Application no: H08-0879-11

Description: Change of use from office to two flats

Location: 64 High Street
Gosberton
Spalding
Lincs
PE11 4NJ
PE11 4NJ

Amendment: Amended red line (reduced) (dwg. no. WEN/1450/11/02A)

PROPOSED BLOCK PLAN 1:500

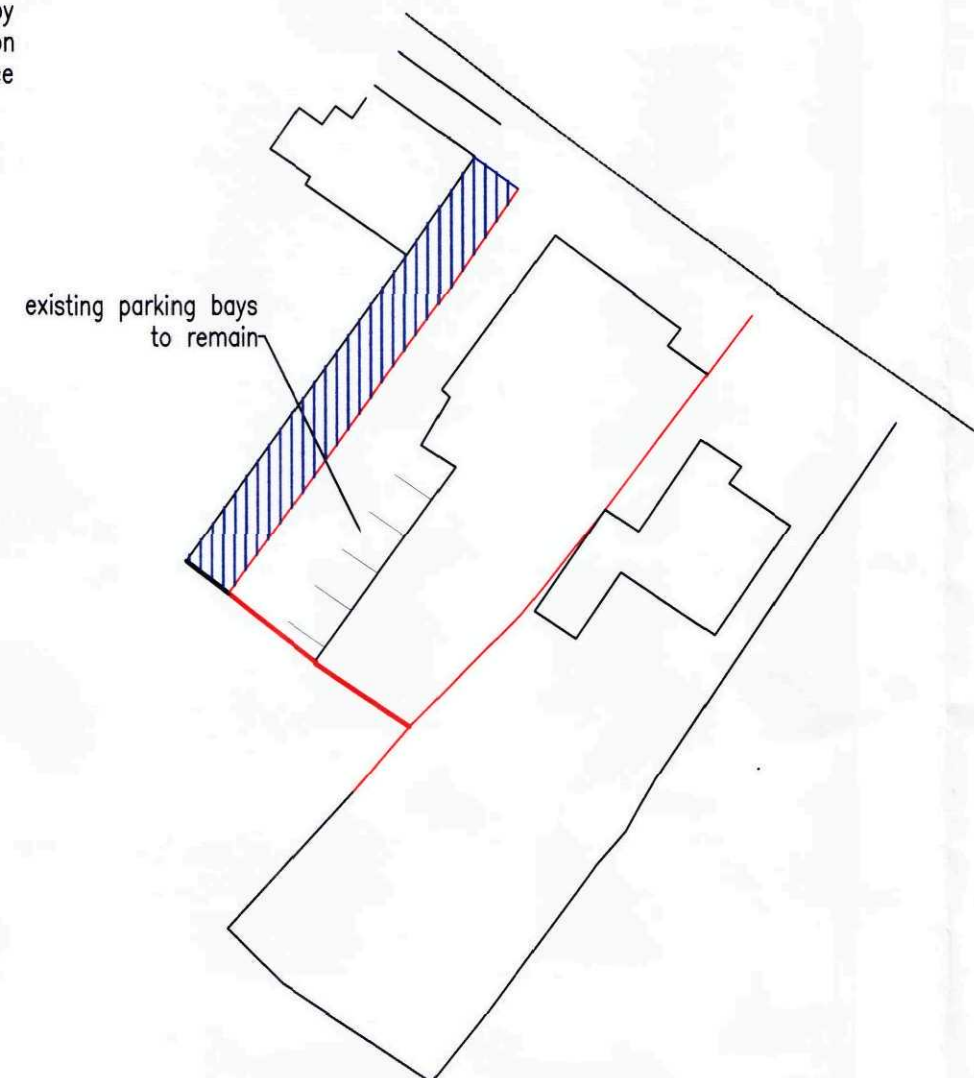
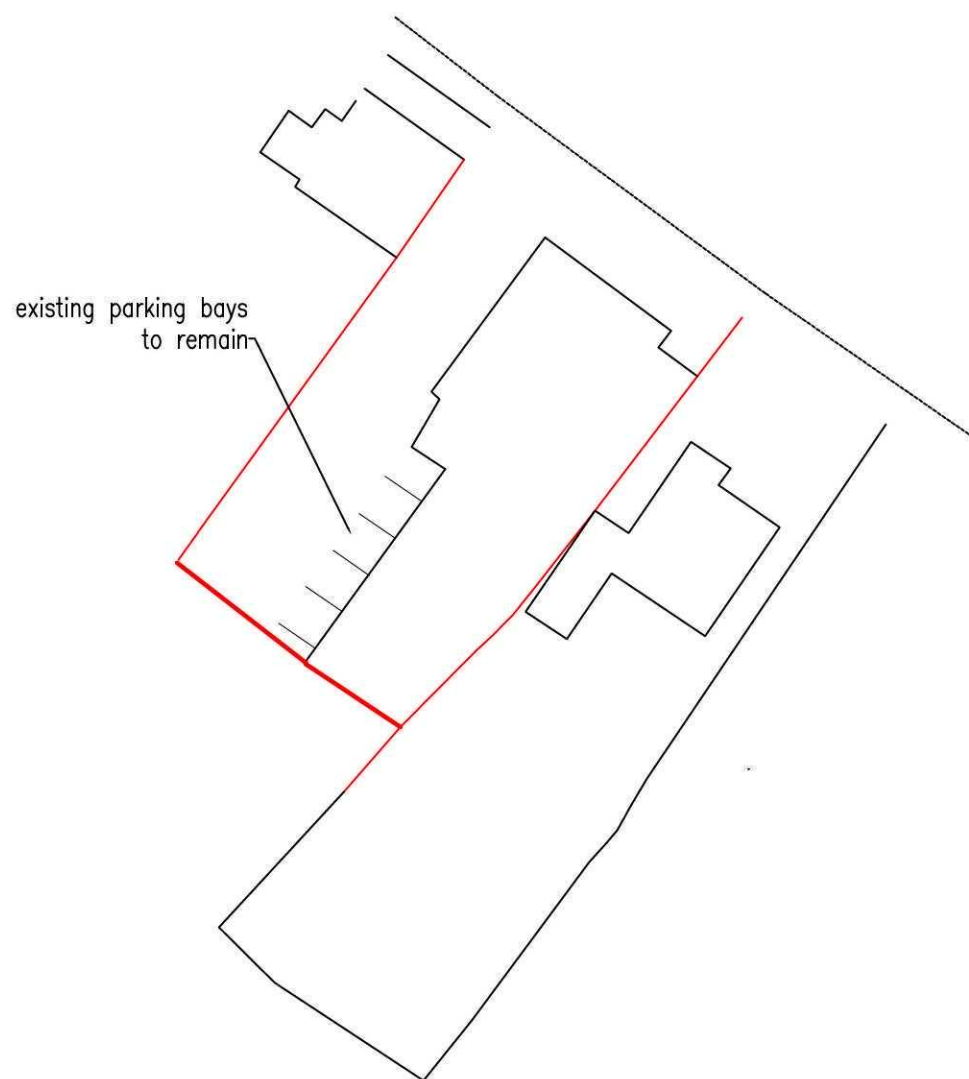
So, the simplest solution would be to submit a revised plan excluding that part of the driveway from the red site outline, instead hatching and annotating it along the lines of 'existing right of way over neighbours and' (assuming that that is the case).

Amended red line (site made smaller, not larger), no reconsults required

Please find attached an amended plan showing the red line excluding the neighbours land.
